Application for Removal or Variation of a Condition following Grant of Planning Permission or
Listed Building Consent

Erection of 1no. two storey dwelling (revised scheme following grant of planning permission ref. 22/00492/FUL)

AT: Land Adj To 25 Hales Road Cheltenham

23/00444/FUL

Project / Drawing No: 21.20.018 PL104 Rev C

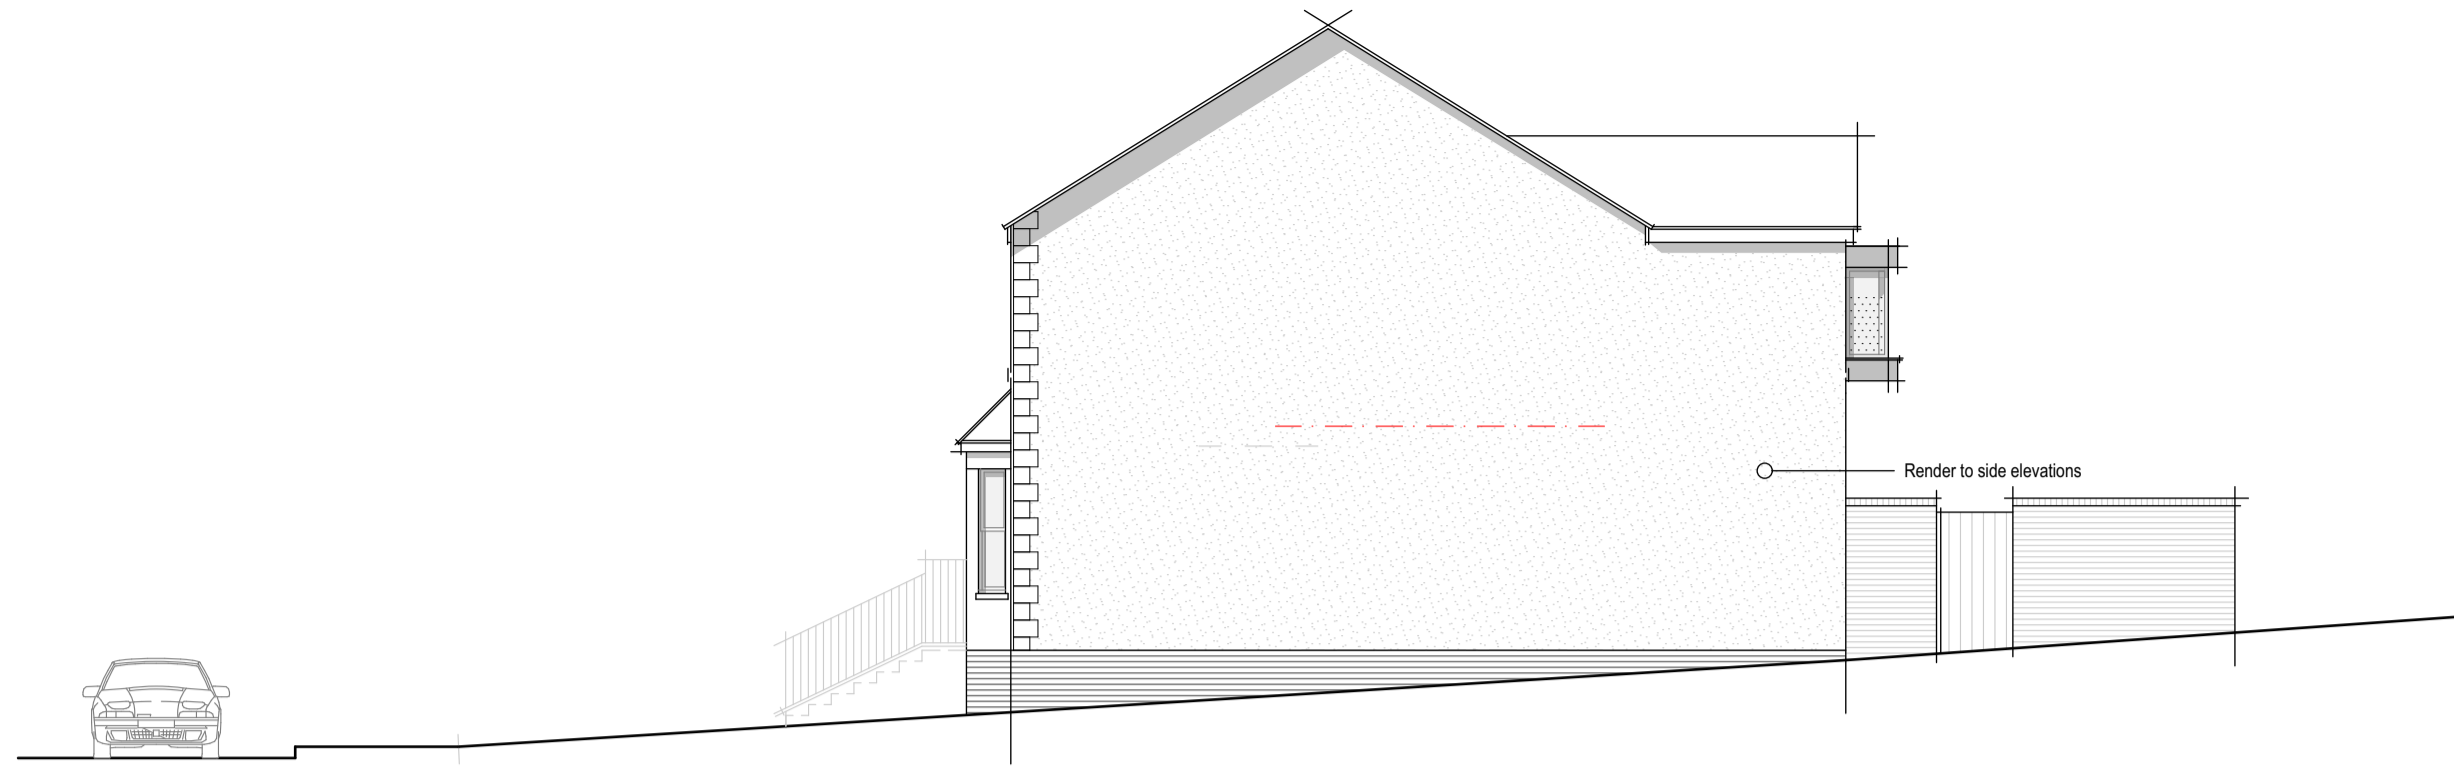
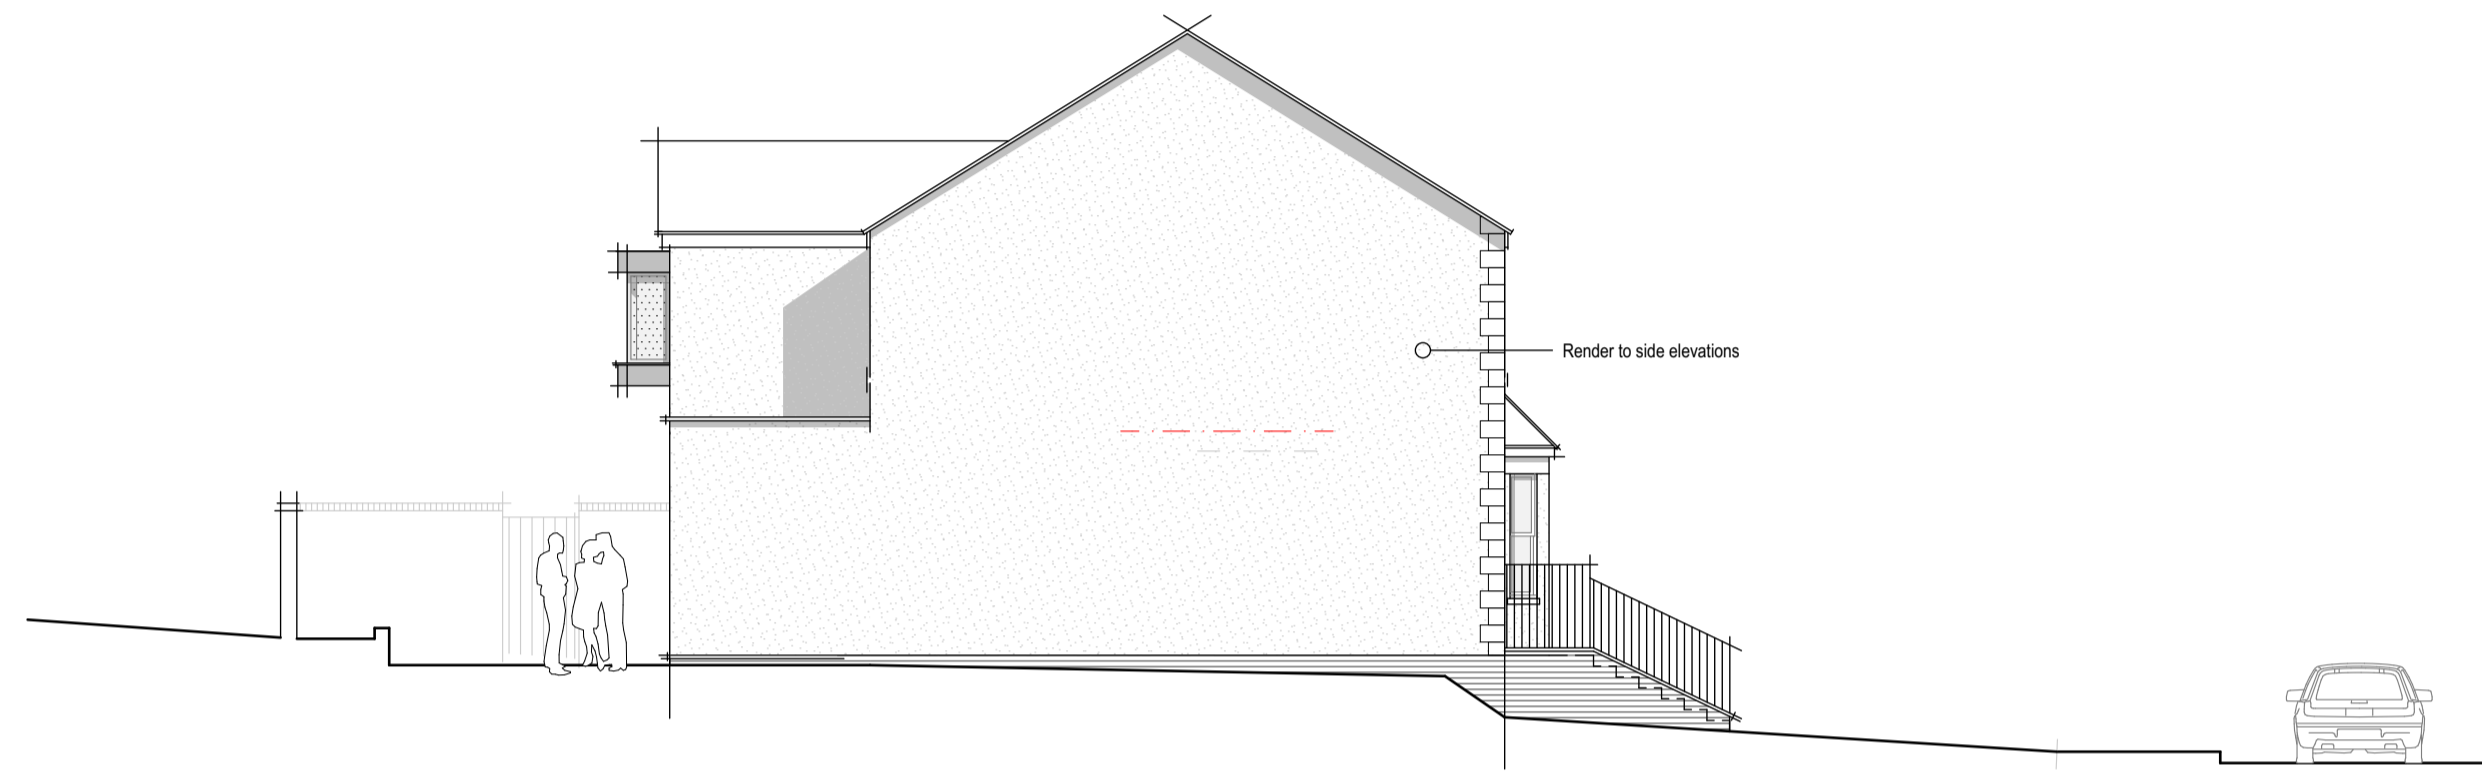
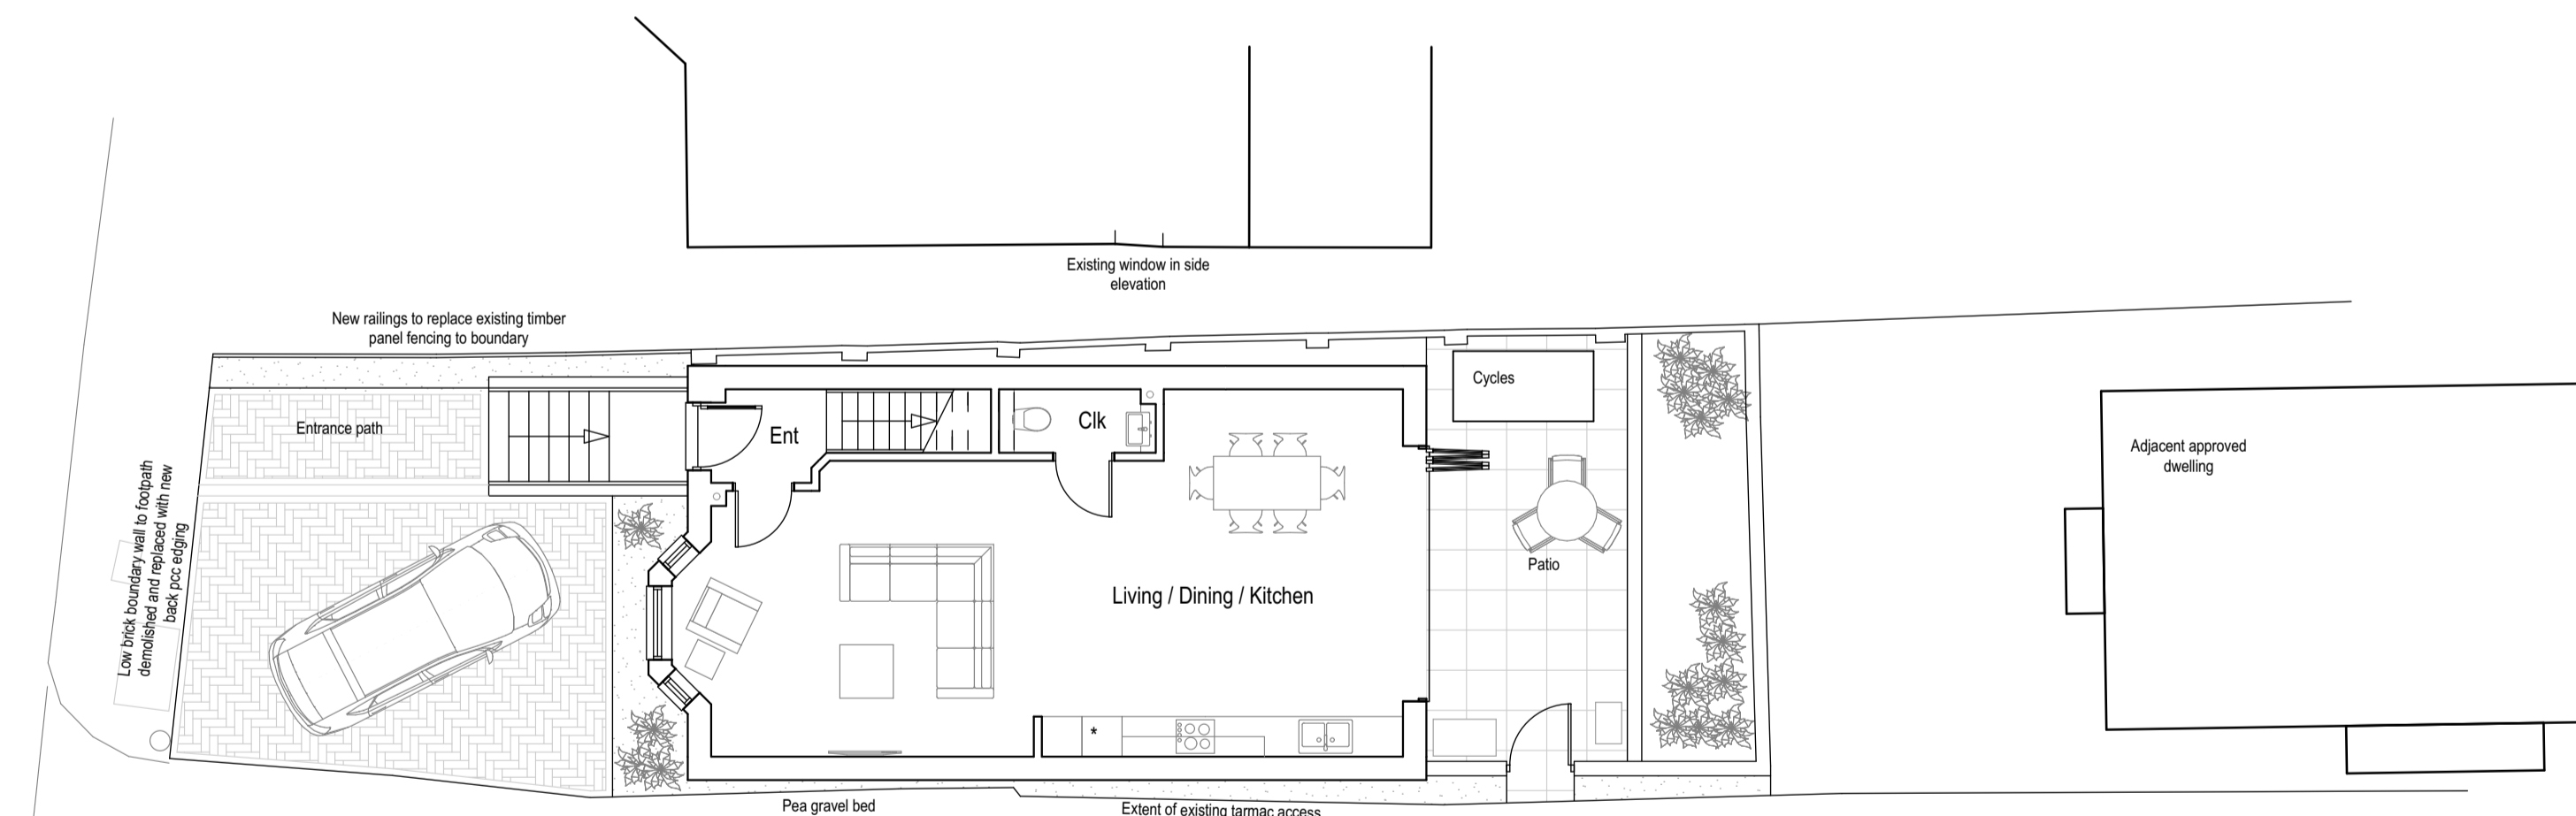
Following discussion with the case officer, the decision has been made to change the materiality on the three elevations to better tie in to the local character of the site and adjacent buildings.

Condition 2 to refer to the revised drawings;

21.20.018 PL104 REV C
